ENG-SF23001-R1-CDs.pdf Markup Summary

SF-23-001

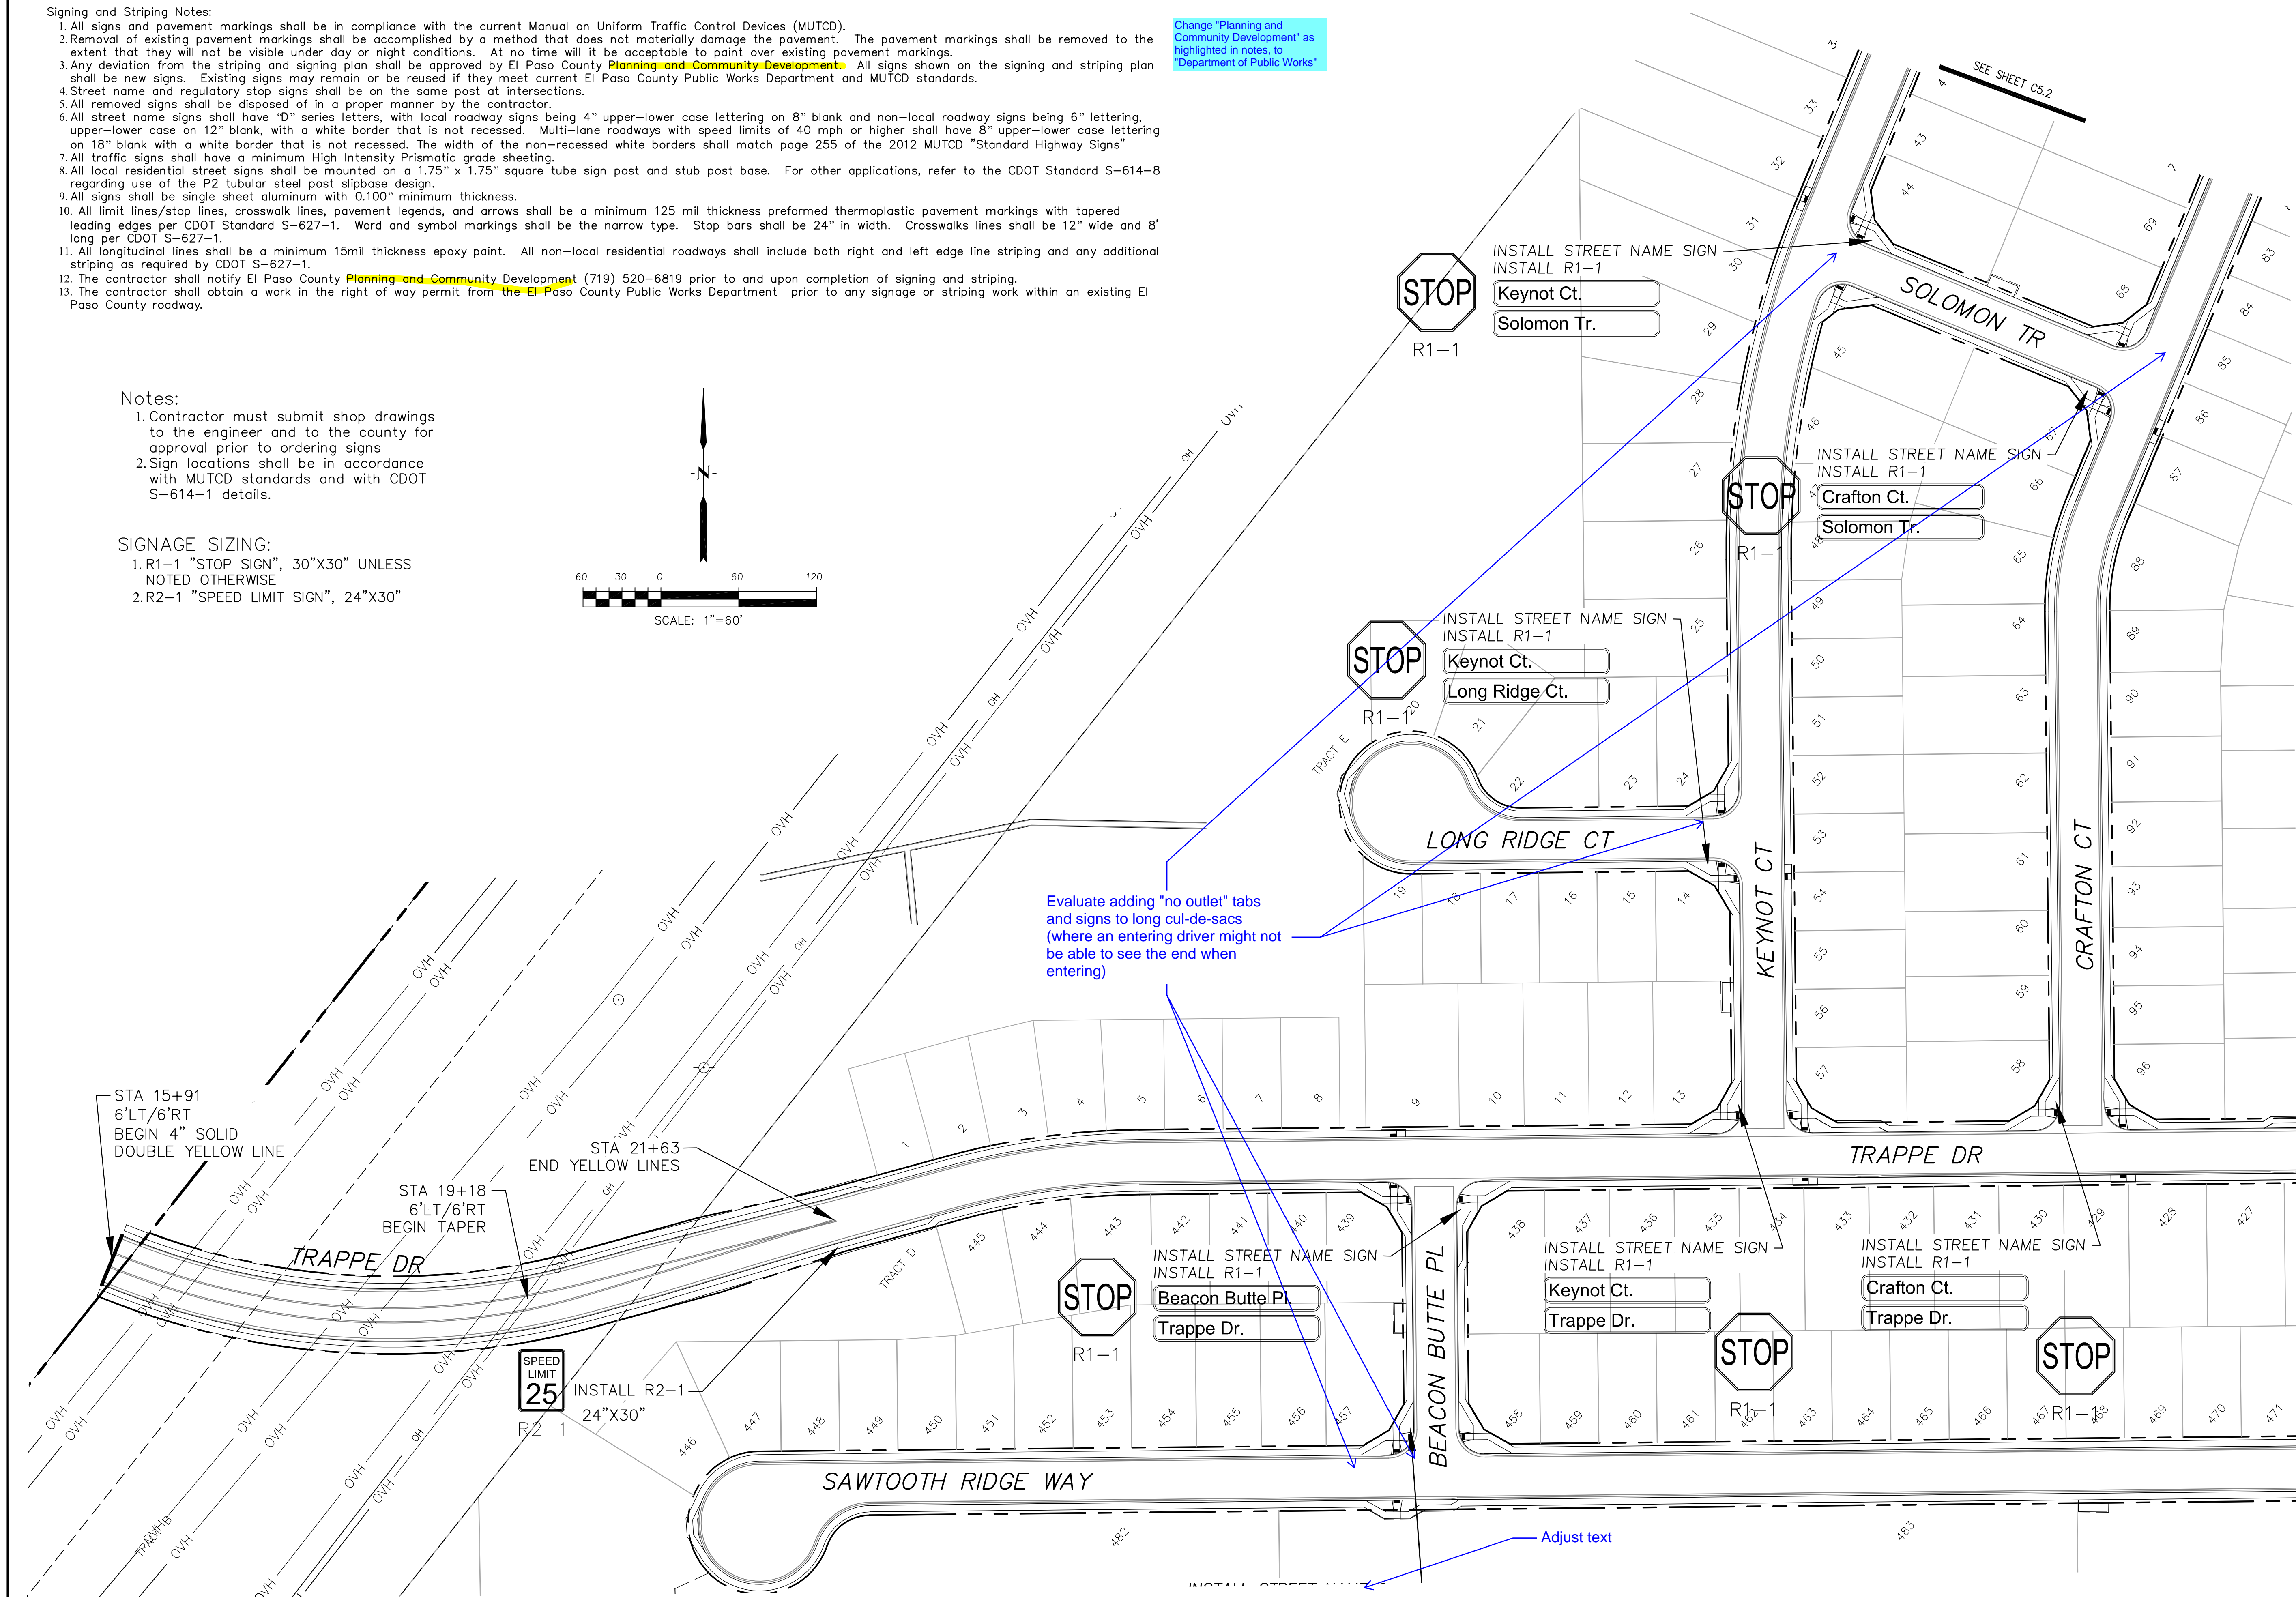
Change "Planning and Community Development" as highlighted in notes, to "Department of Public Works"

Change "Planning and Community Development" as highlighted in notes, to "Department of Public Works"

SAWTOOTH RIDGE WAY

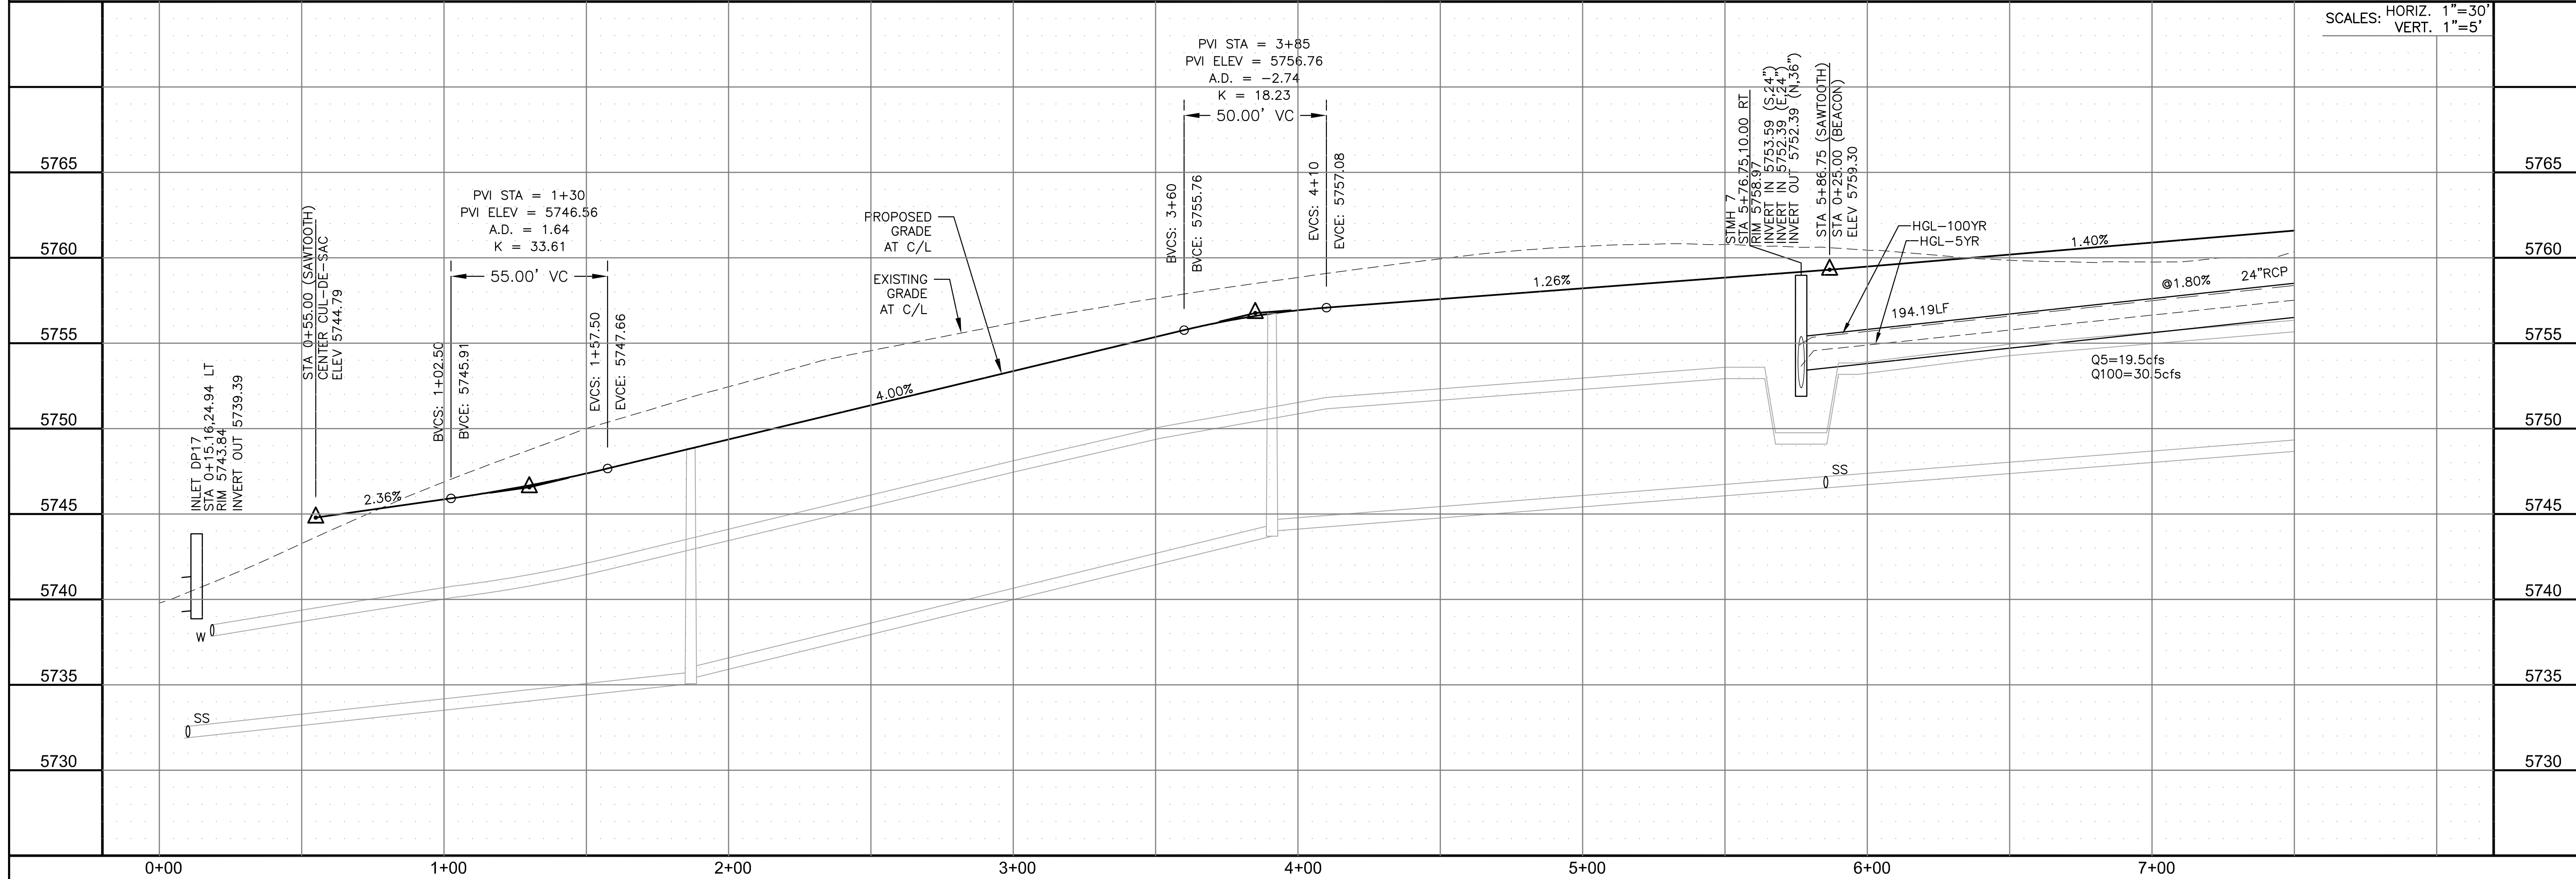
Please provide profile for cul-de-sac bubble

**SALT SPRING WAY**

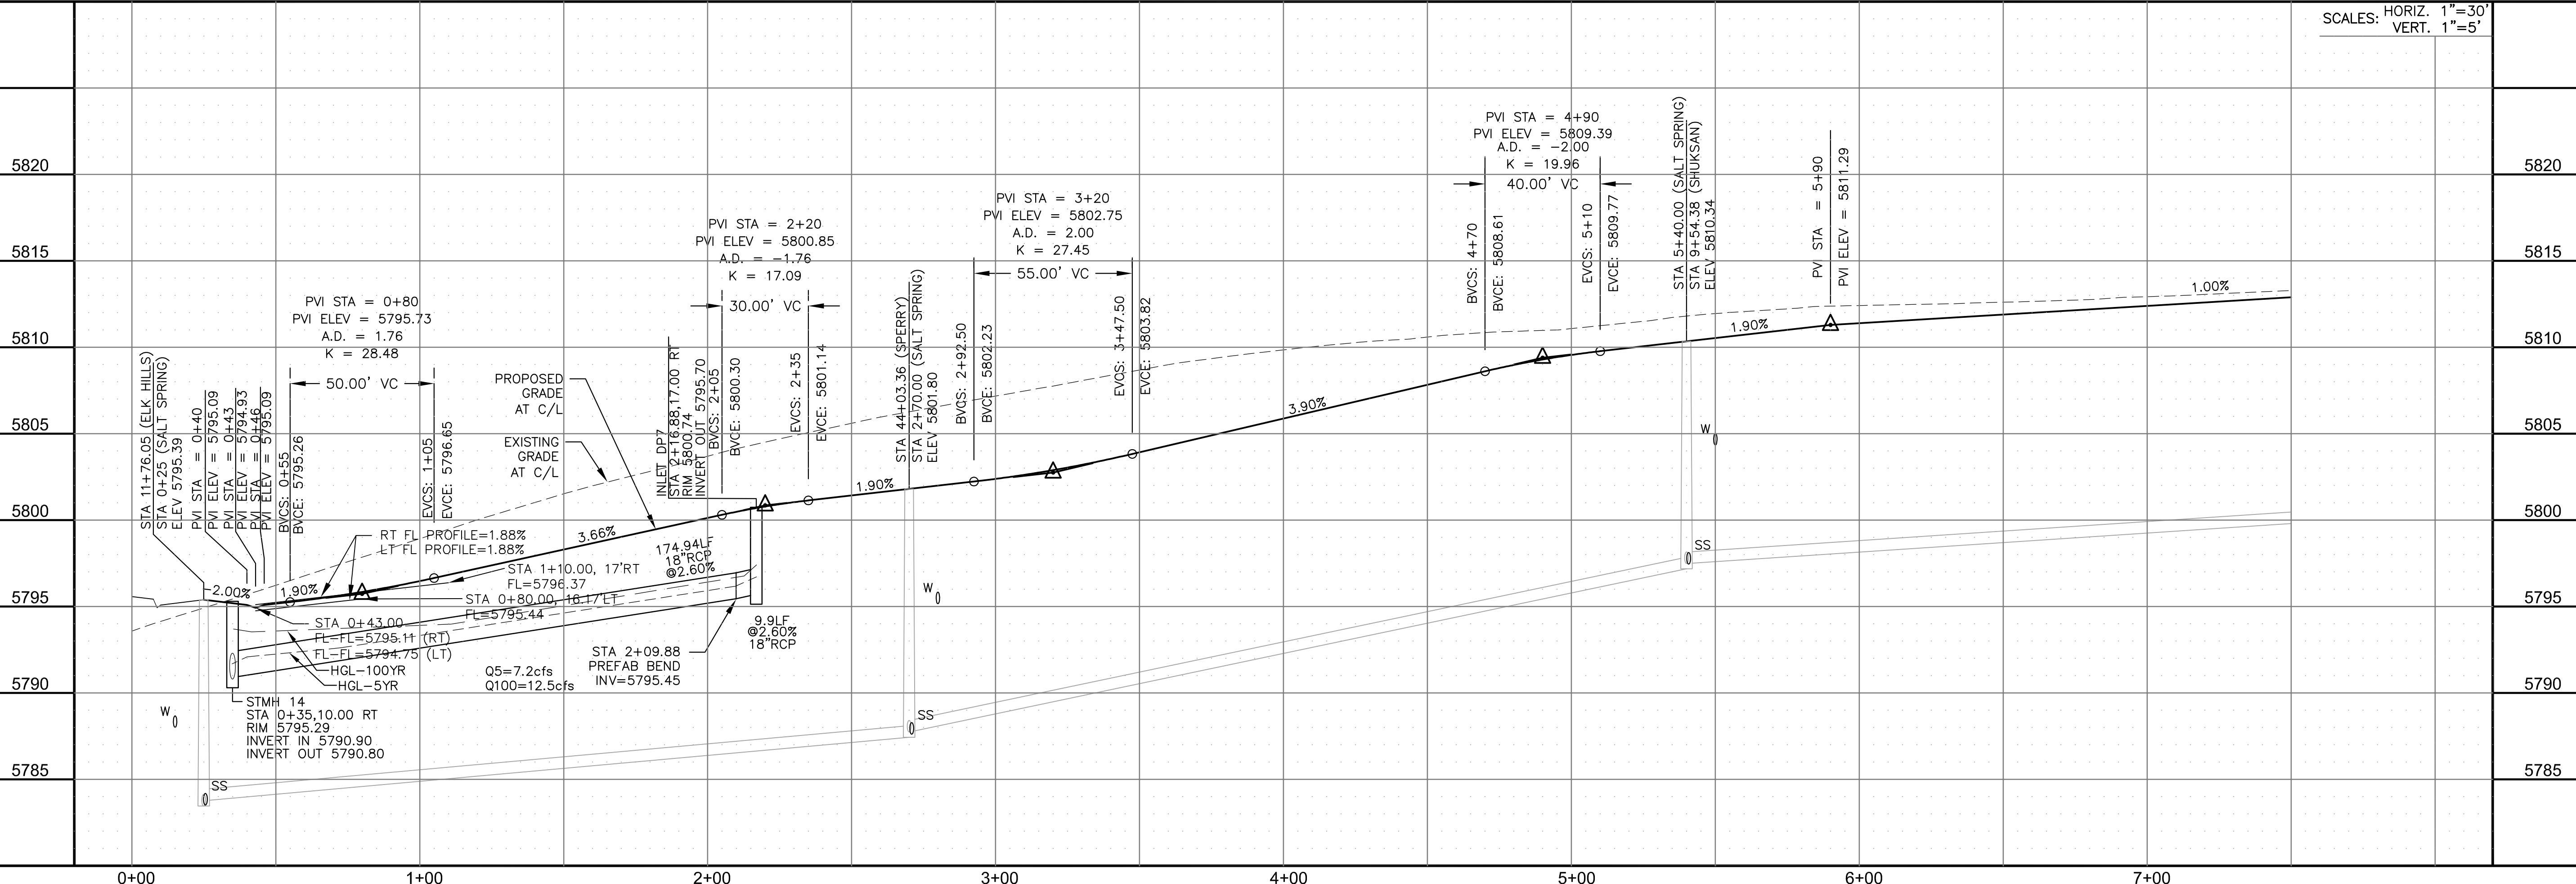
Call out mail kiosk easements
